A1 Birtley to Coal House
Scheme Number: TR010031
Applicant's Response to Deadline 6

Applicant's Response to Deadline 6 Submissions

Rule Number:	Rule 8(1)(c)
Planning Inspectorate Scheme Reference	TR010031
Application Document Reference	Applicant's Response to Deadline 6 Submissions
Author:	A1 Birtley to Coal House Project Team, Highways England

Version	Date	Status of Version
Rev 0	2 June 2020	For Issue

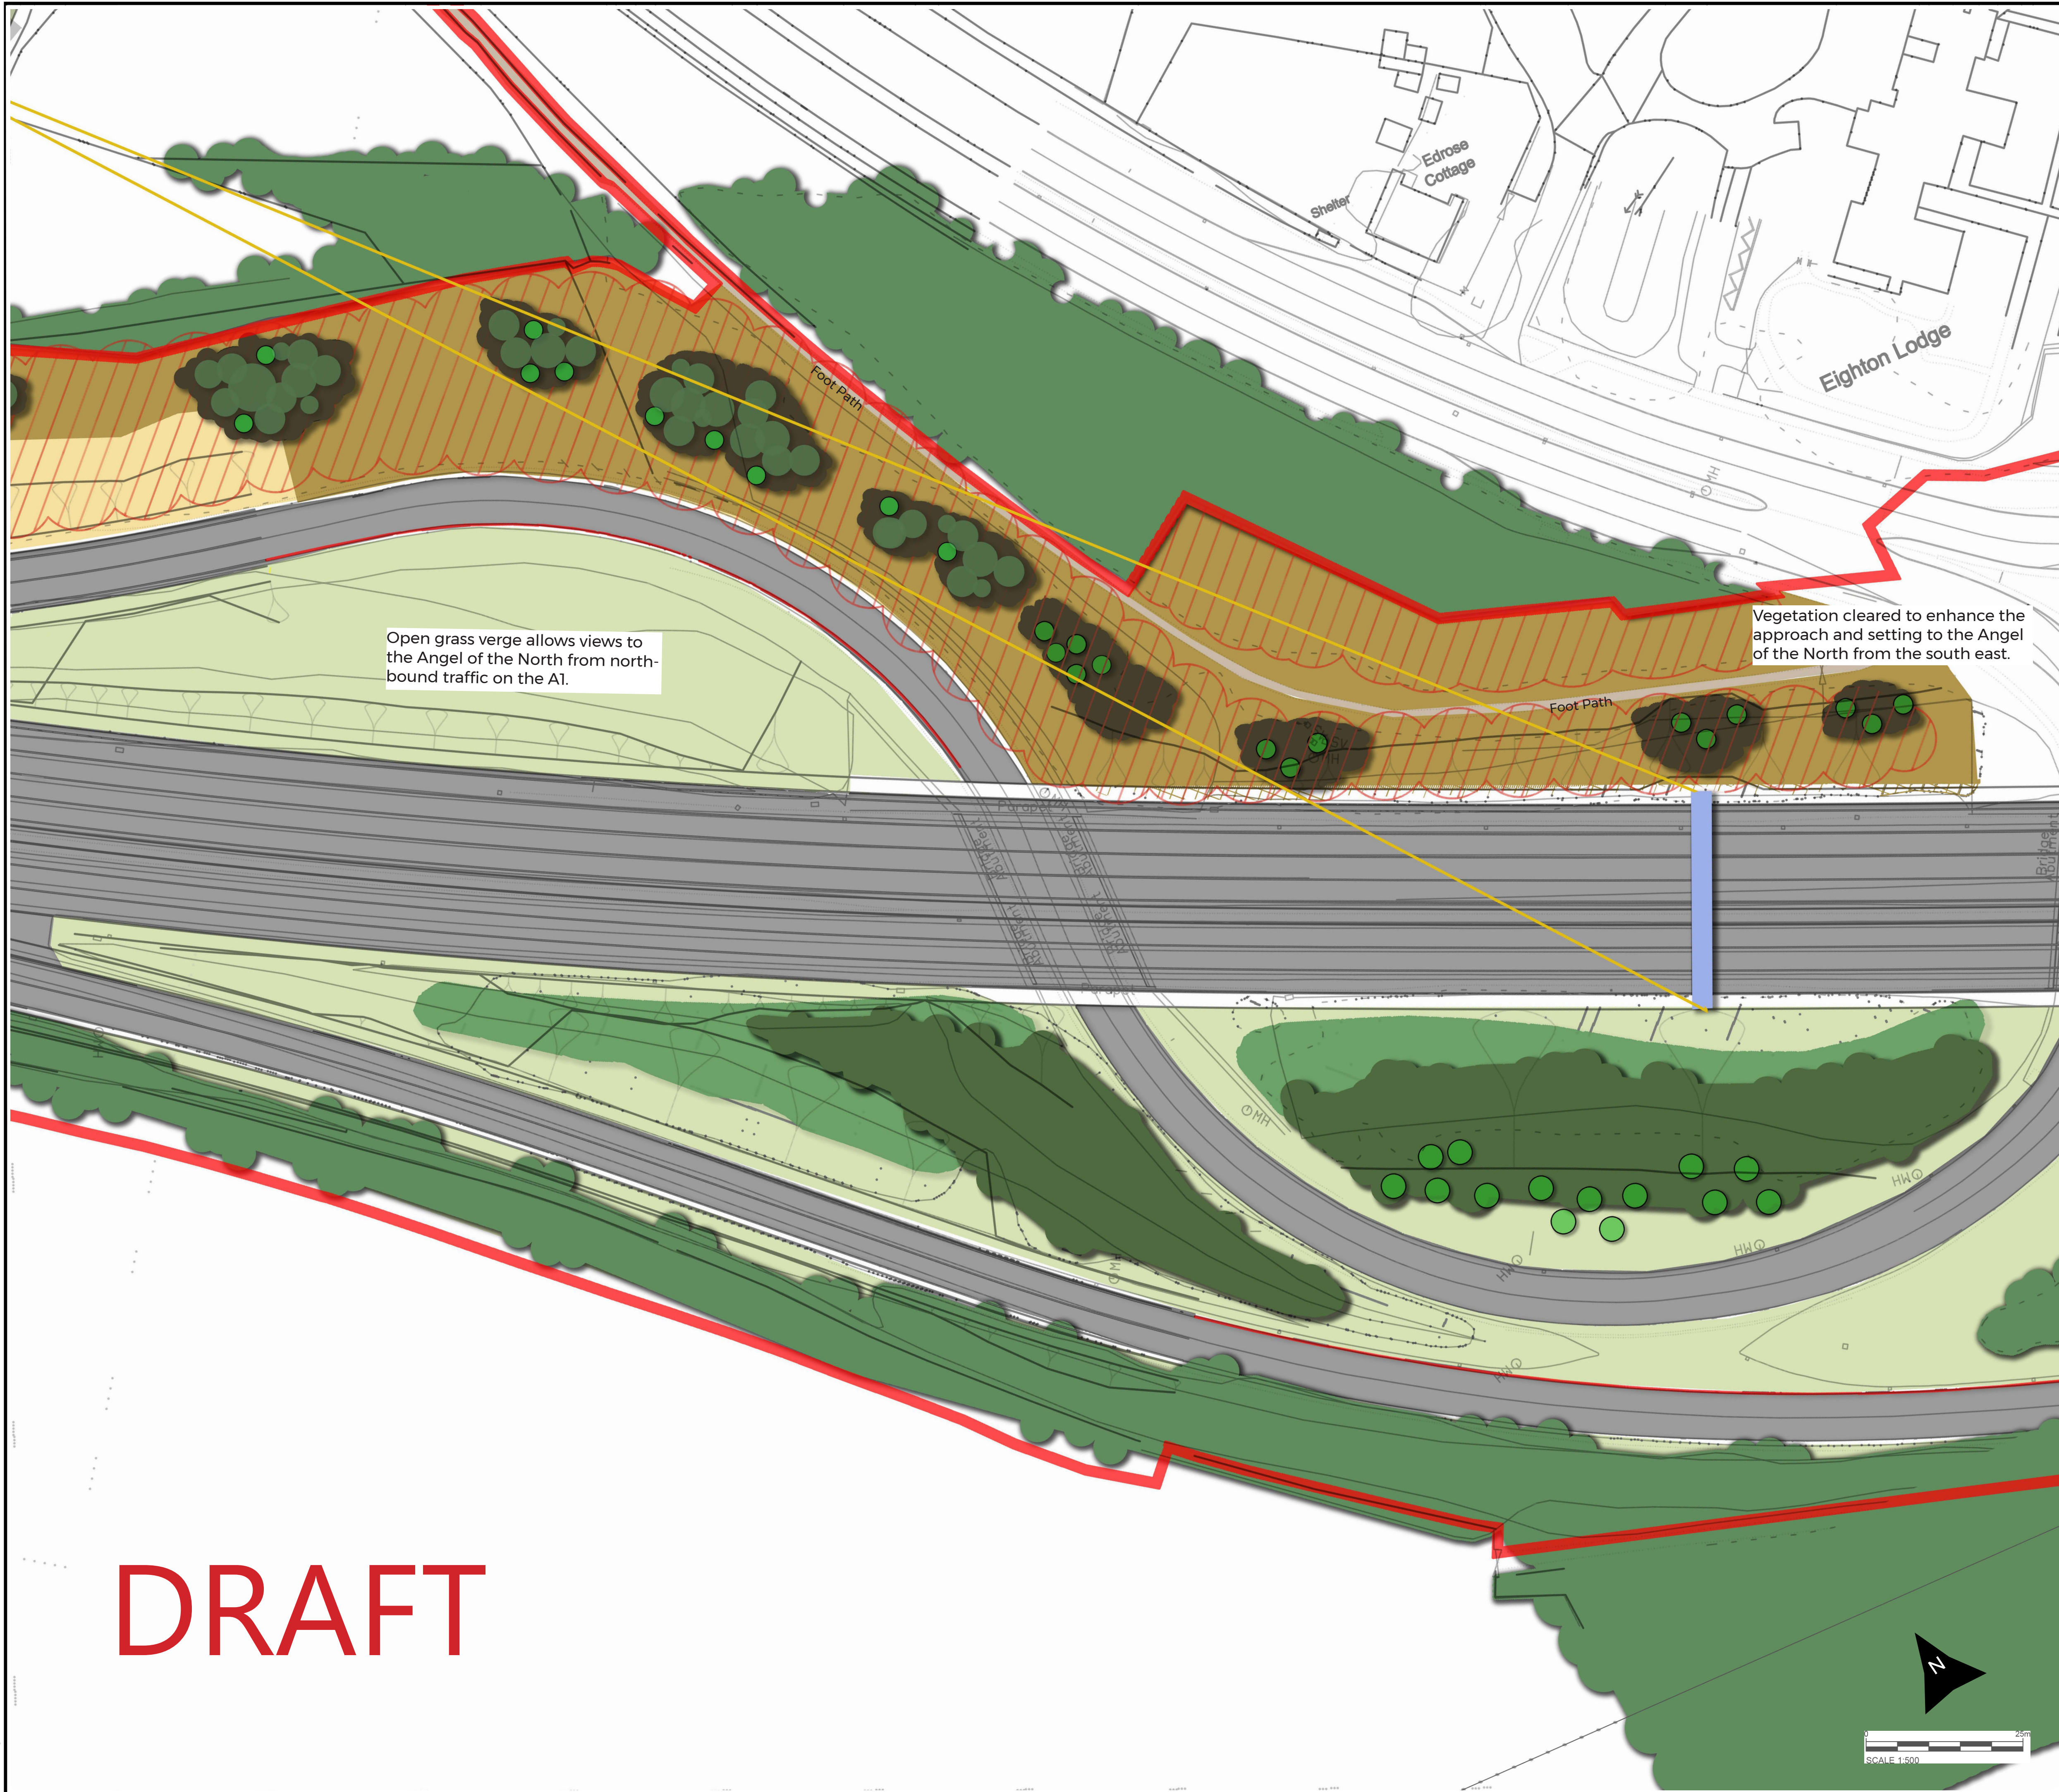
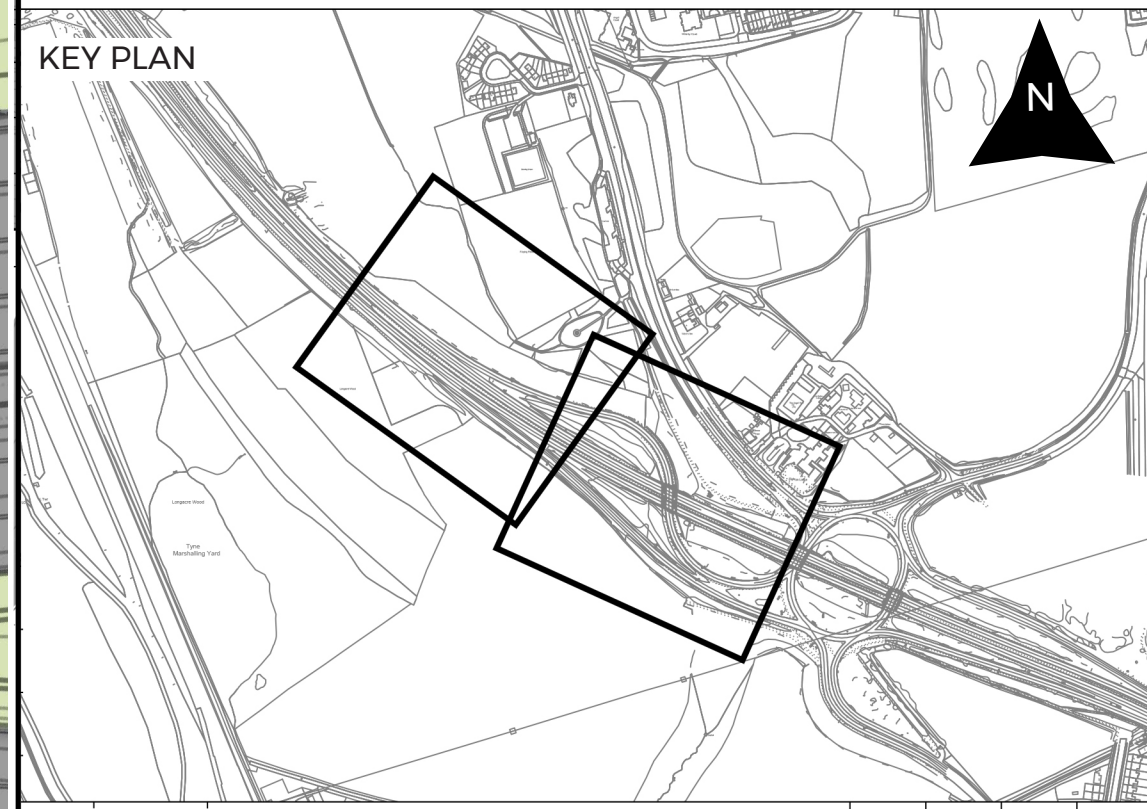
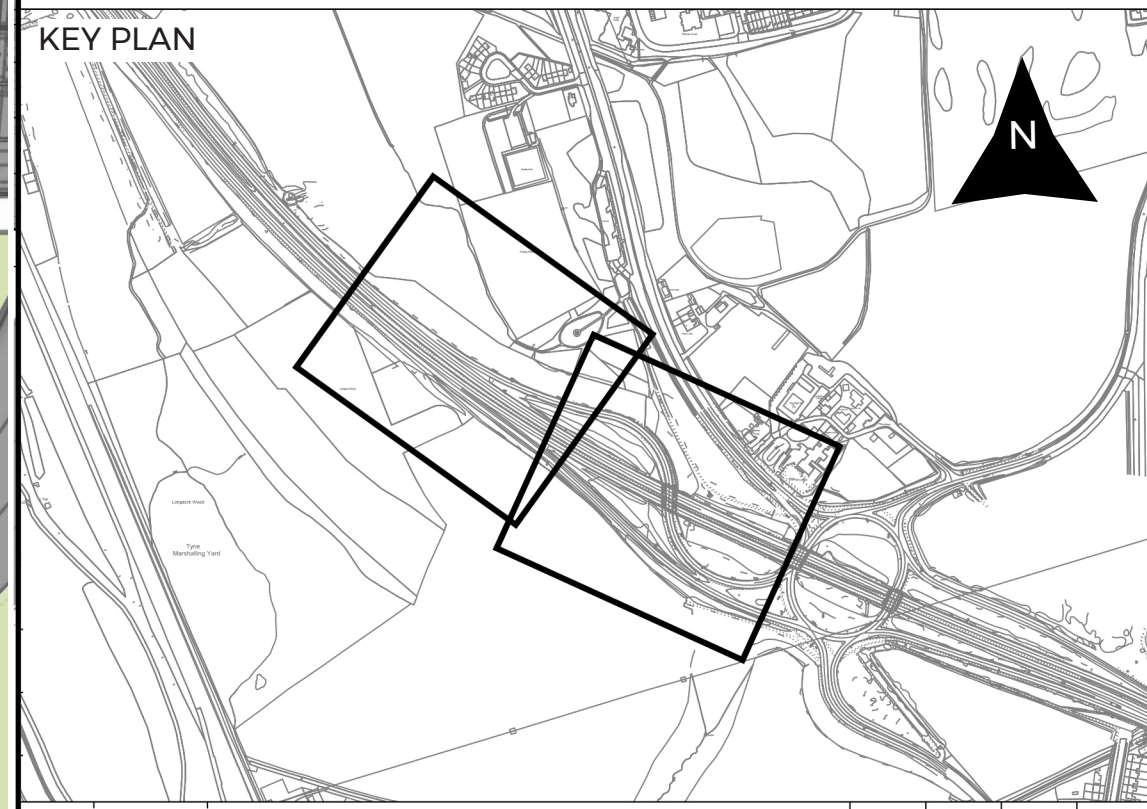
2.5.1.a – Landscape mitigation		
	Highways England have created, and shared, the PDF TR010031-000988-Appendix 1A -in response to our latest submission.	The Applicant presumes TR010031- 000988-Appendix 1A is referring to Applicant's Responses to ExA's Second Written Questions, Appendix 2.5A - Angel of the North Sketch Proposal [REP4-044].
	The design seems to show the planting of low scrubs and clearing of vegetation to open up various sight lines to the Angel of the North and depicts these sight lines (marked in yellow) in relation to the gantries (marked in blue) in closest proximity to the Angel of the North.	<p>The design referred to by the respondent is the draft design proposed by the Applicant, which is currently being discussed with Anthony Gormley Studio via Gateshead Council. The Applicant considers that this design is the final draft and is seeking to secure agreement on this with Gateshead Council and indirectly with Anthony Gormley Studio in due course.</p> <p>The extent of the works outlined in the design are those within the Order limits, and as such are under the Applicant's ownership. Gateshead Council has provided feedback on previous drafts of the design, which, where appropriate, the Applicant has incorporated into the current draft design, with a view that, if agreed and implemented, it would contribute significantly to the vision for 'Option 3 – Revealing the Angel' outlined in the Southern Green Report, 'Options Appraisal for Managing and Enhancing the Angel'.</p> <p>This draft design, as set out in the Applicant's Responses to ExA's Second Written Questions, Appendix 2.5A - Angel of the North Sketch Proposal (Rev 0) [REP4-044], does provide that that some of existing planting would be removed and areas replanted with the inclusion of scrub type species.</p> <p>The Applicant will share the design with the ExA when agreement is reached with Gateshead Council, and indirectly with Anthony Gormley Studio.</p>

Again, all assessments have been made based on current vegetation cover as the baseline and the Applicant has stated that they will not consider undertaking any further analysis. We would like further reassurance that the vegetation on the embankments in the nearby vicinity to the Angel of the North consists of low-lying shrubbery. To	<p>As stated in the Applicant's response to WQ 2.0.7 in the Applicant's Responses to ExA's Second Written Questions [REP4-052], the position of the Applicant remains that the Scheme has been assessed against the existing baseline, which includes the presence of the existing tree coverage, and includes measures to mitigate the effects of the Scheme in its existing landscape.</p> <p>The Guidelines for Landscape and Visual Impact Assessment (3rd Edition) requires the assessment "to</p>

<p>Crucially the site lines depicted are from the Angel of the North rather than site lines from vehicles on the A1 towards the Angel of the North. We are most concerned by the negative impact of the scheme on views for A1 users, and again would argue that TR010031- 000988-Appendix 1A does not go far enough to illustrate the disruption of views for road users</p>	<p>The sightlines from the Angel of the North towards the gantries at Chainages 12450 and 12870 reflect Viewpoint 26 (refer to Figure 7.5 Viewpoint Photos – C [APP-060] of the ES and the assessment outlined in Chapter 7: Landscape and Visual [APP-028] of the ES). These were identified, in discussion with Gateshead Council, to demonstrate the potential impacts of the Scheme on views from the Angel of the North. The removal of the majority of the planting that currently screens the Angel of the North, and within the Order limits, will also open up views from the A1. Where trees are retained or proposed, they are to ensure that the proposed gantries do not adversely and significantly impact the views from the Angel of the North and change the findings of Chapter 7: Landscape and Visual [APP-028] of the ES.</p> <p>The Applicant understands the mention of TR010031- 000988-Appendix 1A is referring to the Applicant’s Responses to ExA’s First Written Questions, Appendix 1.5 A - Angel of the North Narrative. As has previously been explained in the Applicant’s Response to Deadline 4 [REP5-010], Table 1, 2.0.7 a, b and c, the assessment of effects on landscape character and its visual effects (see Chapter 7: Landscape and Visual [APP-028] of the ES), including those that would potentially affect views of the Angel of the North, has been undertaken by a Chartered Landscape Architect with over 20 years’ experience in the assessment of highway schemes. In particular, the assessment has followed the approach as set out in Appendix 5.3 - ‘Approach to Photography and Photomontages’ [REP3-005] provided in the Applicant's Comments on Local Impact Report. This aligns with the guidance within Design Manual for Roads and Bridges Volume 11 Section 3 Part 5, Interim Advice Note 135/10 Landscape and Visual Effects Assessment, Guidelines for Landscape and Visual Impact Assessment (3rd Edition) and TGN 06/19 Visual Representation of development proposals. This extends to the selection of visual receptors and preparation of supporting visual information, including the preparation of photomontages in order to assess the effect against the existing landscape and visual baseline.</p>

<p>The proximity of the Eighton Lodge gantry to the Angel of the North is most worrying. We would ask that the Applicant considers moving the Eighton Lodge gantry to the South by 150m to minimise negative impacts on views in the immediate approach to the Angel of the North.</p>	<p>The Angel of the North would be visible to the north when approaching Junction 66 Eighton Lodge, as demonstrated in Plate 10 of the Applicant's Responses to ExA's First Written Questions, Appendix 1.5 A - Angel of the North Narrative [REP2-019]. A specific reference was made to the gantry location at Chainage 12870 in the Applicant's Response to Deadline 4 [REP5-010], Table 1, 2.0.8, which described the effect of the gantry at this location, and the effect on northbound travelers.</p> <p>On passing the gantry at its current location, the Angel of the North would continue to be visible above intervening vegetation. A relocation, 150m to the south at Chainage 12870, would have the effect of a marginally longer (approximately 4 to 6 seconds), unencumbered view, once past the gantry, for the travelling public to the sculpture. It is the professional opinion of the Applicant's landscape architect that such relocation would marginally improve the experience of the travelling public on the A1. However, such relocation would also result in the gantry being located closer to the junction. This would be 40m outside (south) of the allowable tolerances (in accordance with Highways England's guidance at the time as set out in Design Manual for Roads and Bridges Interim Advice Note 144/16 'Directional Signs on Motorway and All-Purpose Trunk Roads: Grade Separated Junctions'), which are described in more detail within the Gantry Details report [REP4-029]. This would provide drivers with less time to assimilate the information and safely navigate the junction, which would increase the likelihood of accidents. The Applicant considers that a marginal improvement in views to the Angel of the North would be insufficient justification to accept a reduction in safety of road users.</p>

Ref:	Comment:	Applicant's Response:
	<p>mitigate against the negative impacts of the scheme, and to return the views of the Angel of the North to their former state, we would ask that the surrounding vegetation remains below the skyline so that the Angel of the North and the mound are clearly visible</p>	<p>describe the landscape as it is at the time”, which is the approach that the Applicant has adopted. Therefore, to assess a development against a different baseline i.e. in relation to the resumption of previous levels of vegetation or the implementation of a remodeled setting that is yet to be committed, would not be in accordance with the aforementioned guidance. In addition, the Applicant was only made aware of the decision to pursue ‘Option 3 - Revealing the Angel’, outlined in the Southern Green Report, ‘Options Appraisal for Managing and Enhancing the Angel’ in February 2020. However, so far as possible (and without compromising other mitigation required for the Scheme as a result of effects upon biodiversity, etc.), the Applicant is continuing to seek a design on the land within its control that can accommodate the aspirations of Gateshead Council, in consultation with Anthony Gormley Studio, in respect of the setting of the Angel of the North.</p> <p>The Applicant would draw the ExA’s attention to the Applicant's Responses to ExA's Second Written Questions, Appendix 2.5A - Angel of the North Sketch Proposal (Rev 0) [REP4-044] that demonstrates the development of the mitigation design in respect of the proposals associated with the Angel of the North, which are subject to ongoing discussions with Gateshead Council and indirectly with Anthony Gormley Studio.</p> <p>This sketch and the final draft design have sought to identify planting, including small trees that would fulfil the mitigation requirement to screen views of the gantries in views from the Angel of the North. In addition, the draft design includes areas of scrub and open grassed areas which support opening up views from the A1 of the sculpture and the mound. Agreement on the design with Gateshead Council and indirectly with Anthony Gormley Studio would enable the proposals to be incorporated into the landscape mitigation design, as set out in Figure 7.6 Landscape Mitigation Design [APP-061] and secured through the Outline CEMP [REP6-08 and 19] an updated version of which will be submitted at Deadline 8.</p>

Ref:	Comment:	Applicant's Response:
		<p>The Applicant has, with the exception of the request for a verified drive through, provided the information, in line with the guidance outlined above, requested by Gateshead Council as the local planning authority. The Applicant therefore considers that the information provided sufficiently illustrates the disruption of views for road users to inform the examination of the Scheme, on the basis that the sequence of views has been provided via the following documents: Applicant's Responses to ExA's First Written Questions, Appendix 1.5 A - Angel of the North Narrative [REP2-019]; Appendix 1.2A, Cross Sections in the 'Applicant's Comments on Responses to EXA's Written Question' [REP3-004]; and the appearance and detail of the view is contained within the photomontage Appendix 5.2, North Dene Photomontage of the 'Applicant's Comments on Local Impact Report' [REP3-005].</p>
